Please ask for: Ms Iqraa Malik
Email: iqraa.malik@terraquest.co.uk
Telephone: 01212341390
Our Ref: AB/75/21/HH
Your Ref:
Date: 14th June 2021

Application for Planning Permission for Works or Extension to a Dwelling

Location: 54 Tarrant Street Arundel BN18 9DN

SITE + LOCATION PLANS

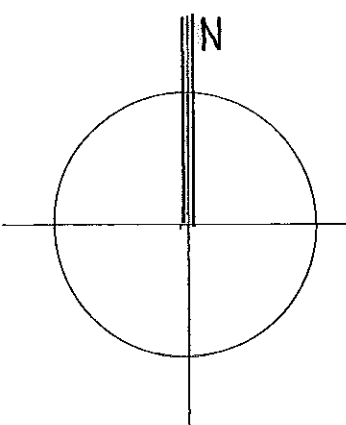
The location and block plan does not measure to scale. Please amend.
